FW: P/5/26/PL

I'm just about to head on site and post the notices for this application, but in reviewing the description and given the size of the rear dormer proposed to the existing bungalow, I think it is worth including a specific reference to the inclusion of the dormer extension within the description and on the notices to be posted.

'1 No 4-bed chalet bungalow, alteration of existing bungalow to include off-street parking and rear dormer extension (resubmission following P/118/25/PL). This application is in CIL Zone 4 and is CIL Liable as a new dwelling.'

Proposed North Elevation 44

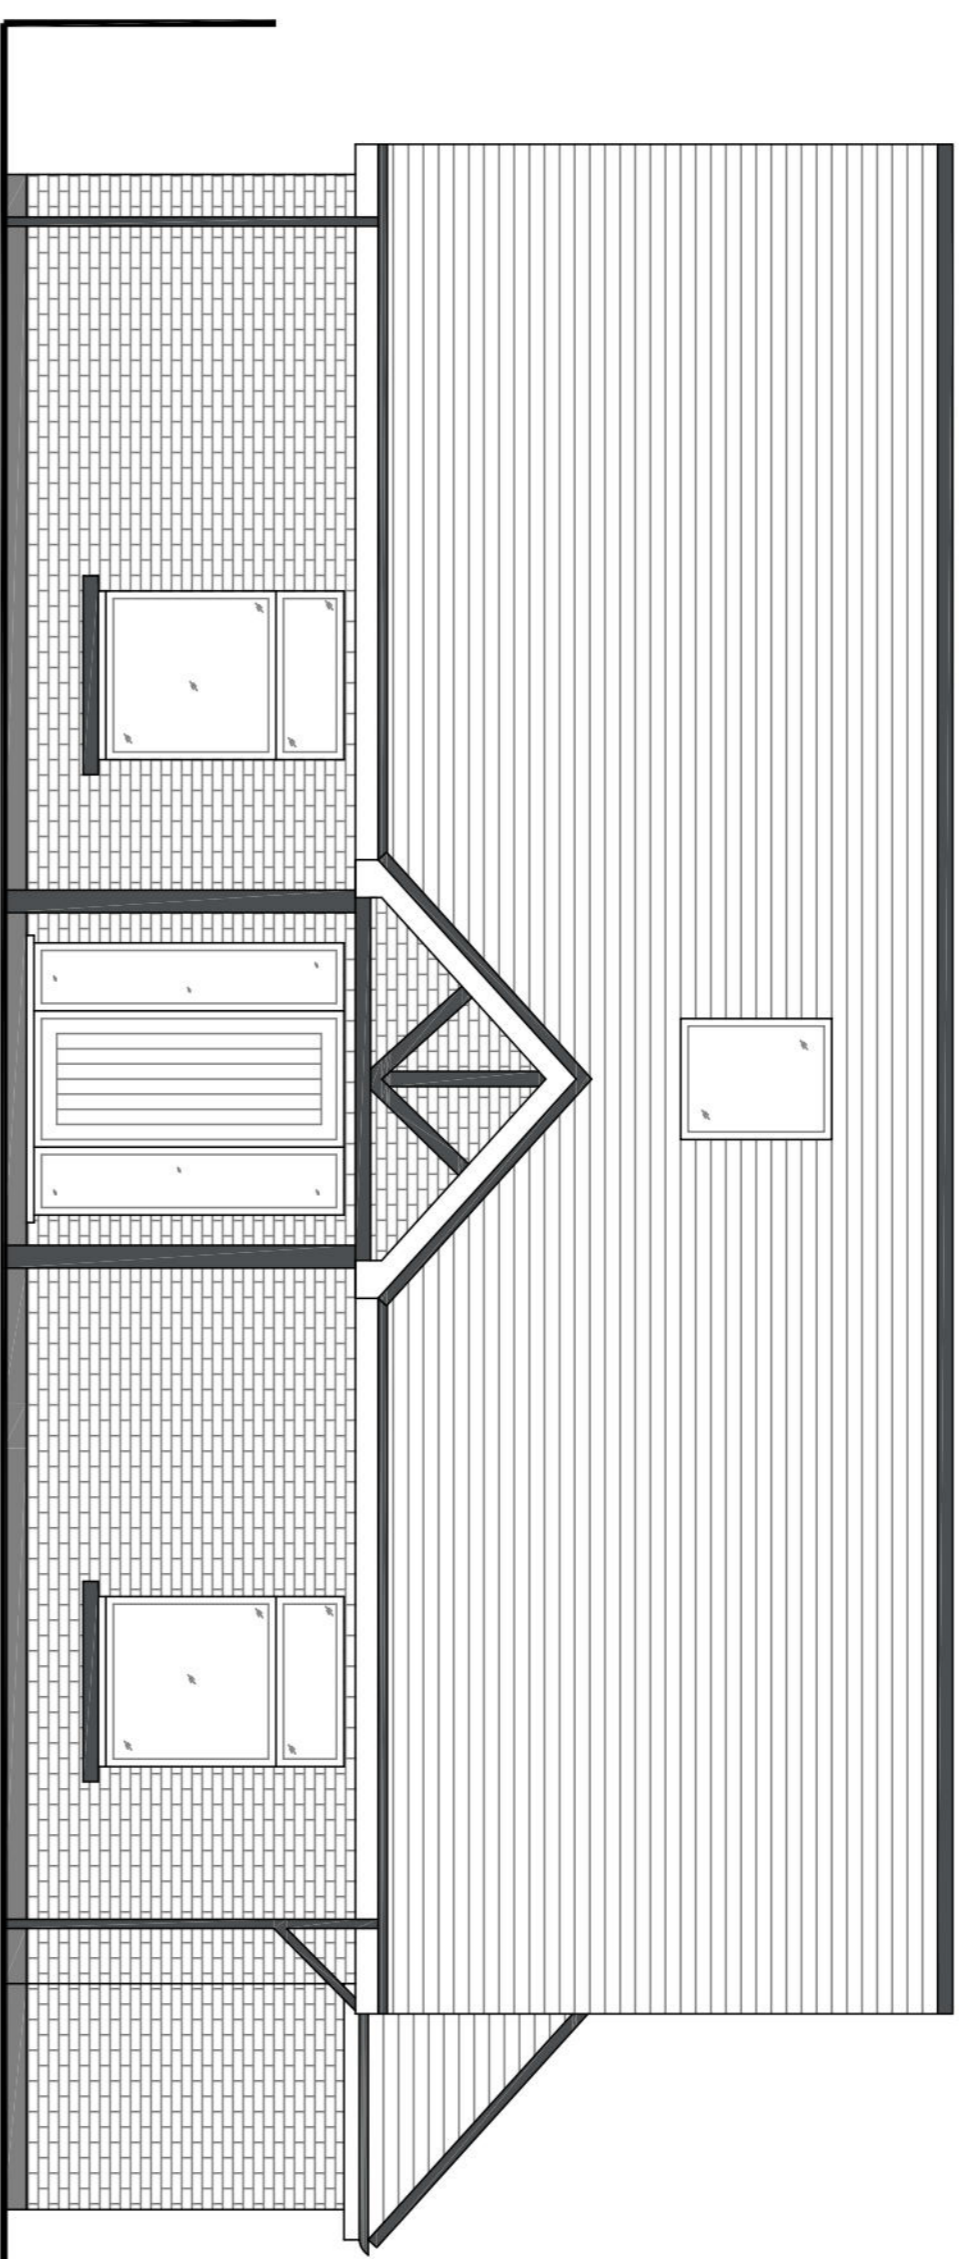
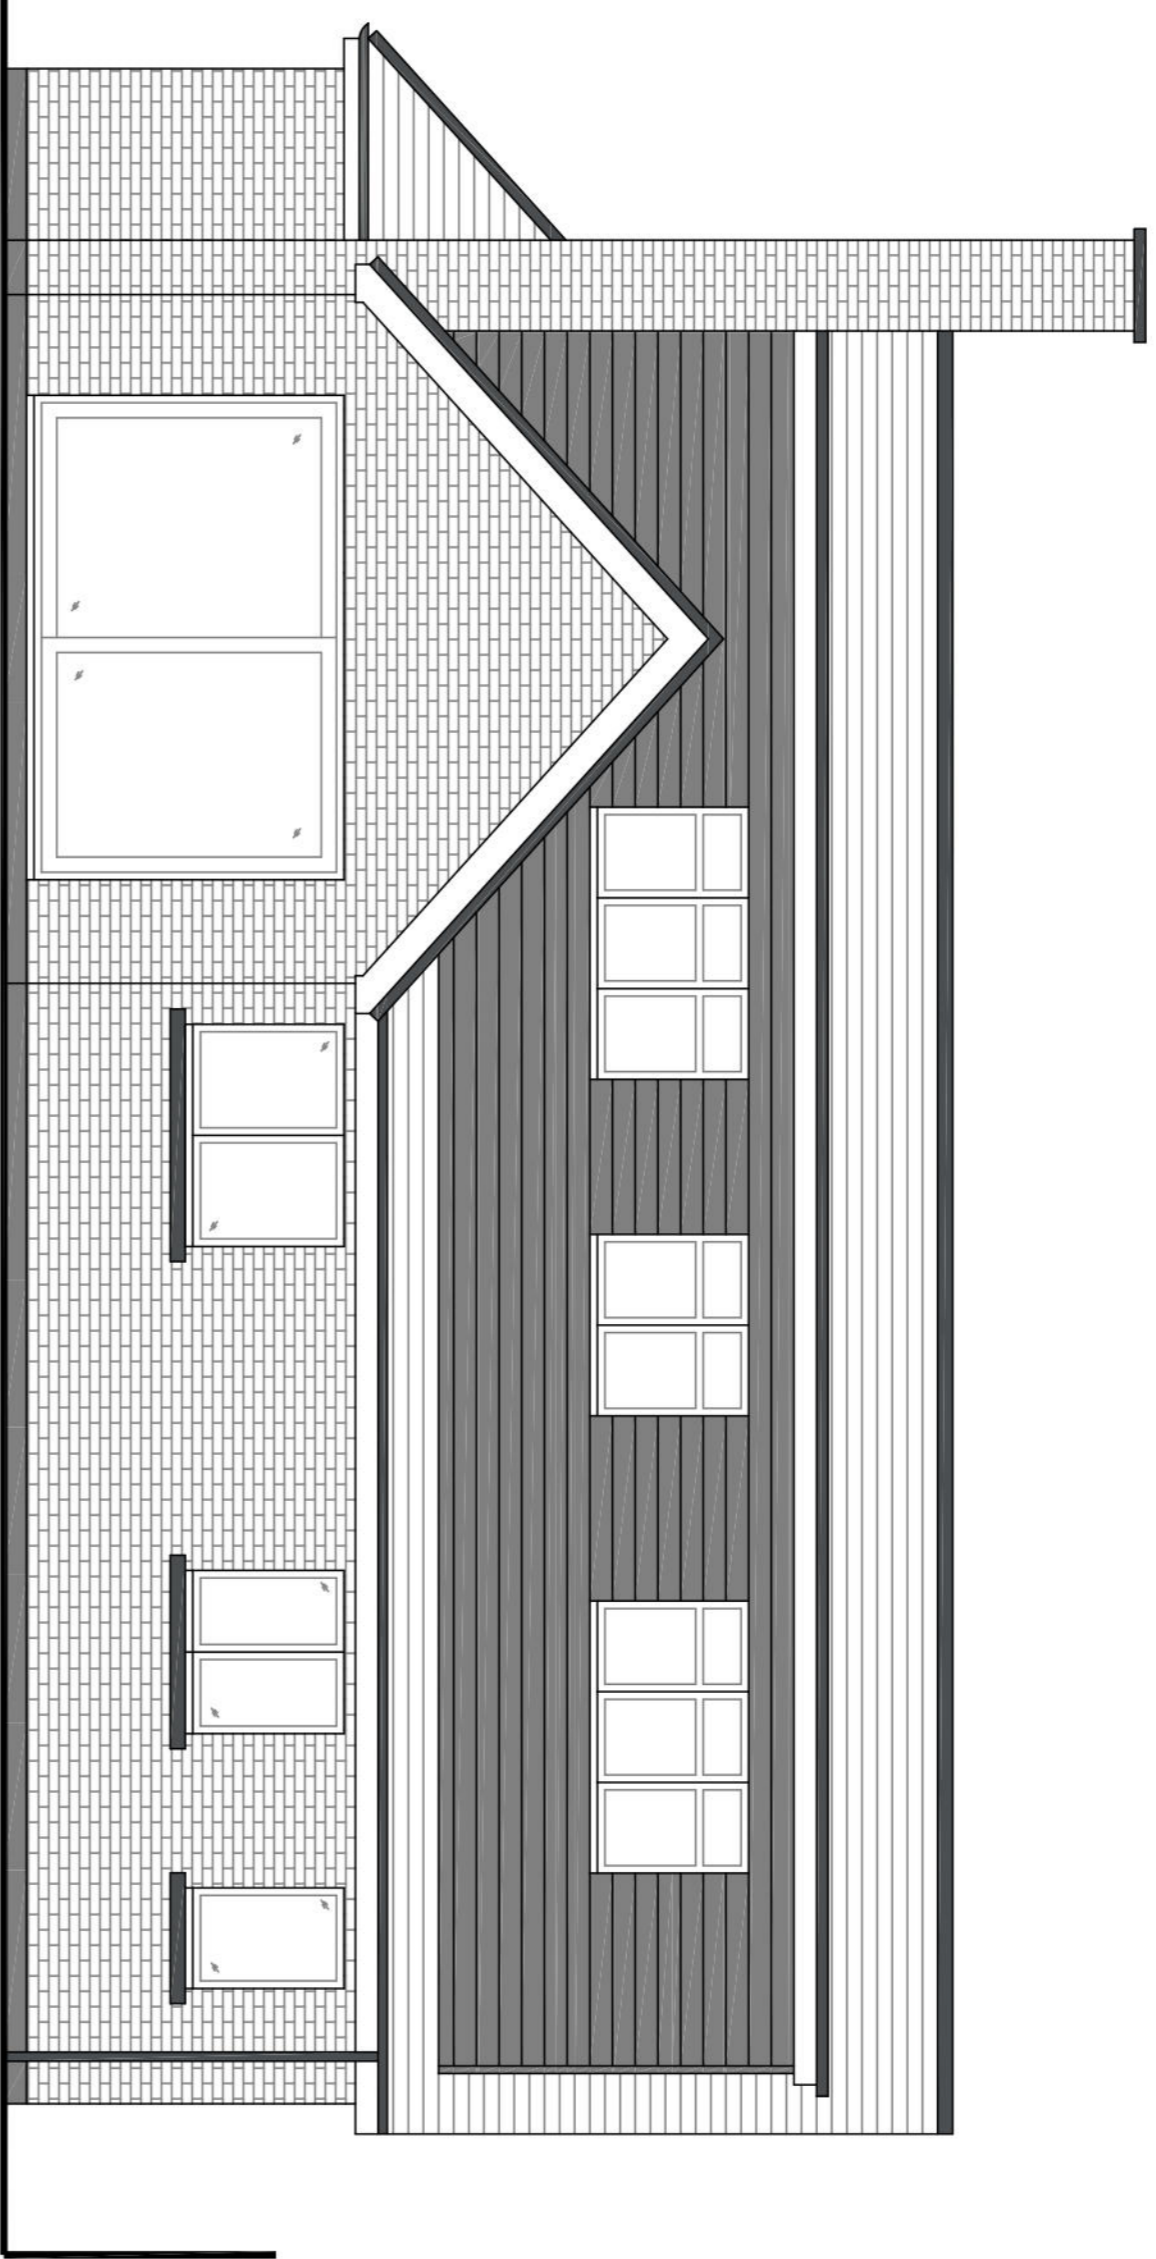
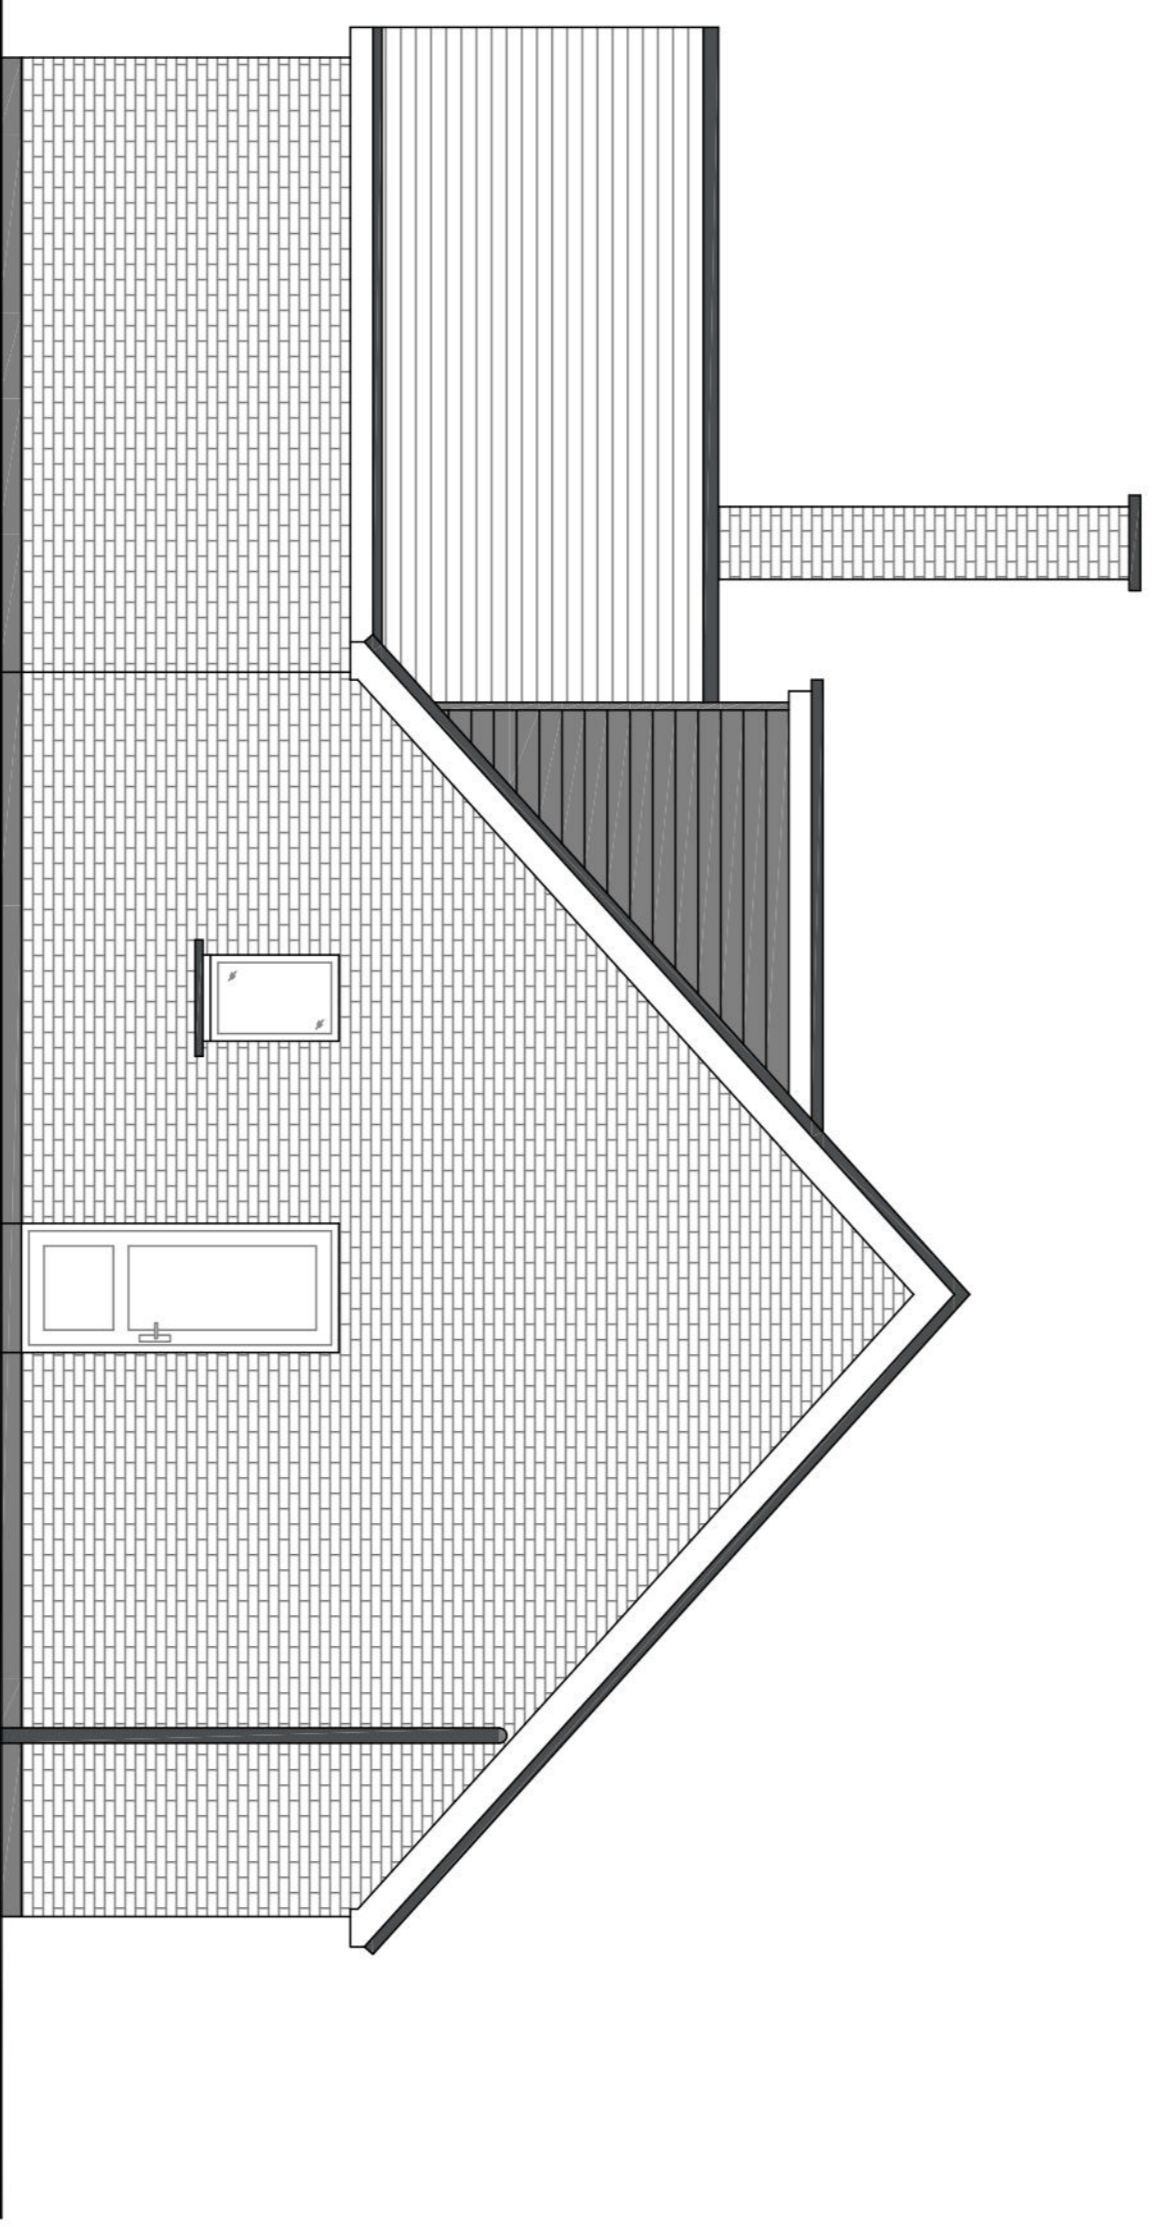
Following review, could I request that the rear dormers of both dwellings are reduced in width, perhaps at least by 0.5m each side, and that they are set back into the roof slope slightly further by perhaps a couple of rows of tiles. Our aim is to reduce their dominance of the rear roof slopes.
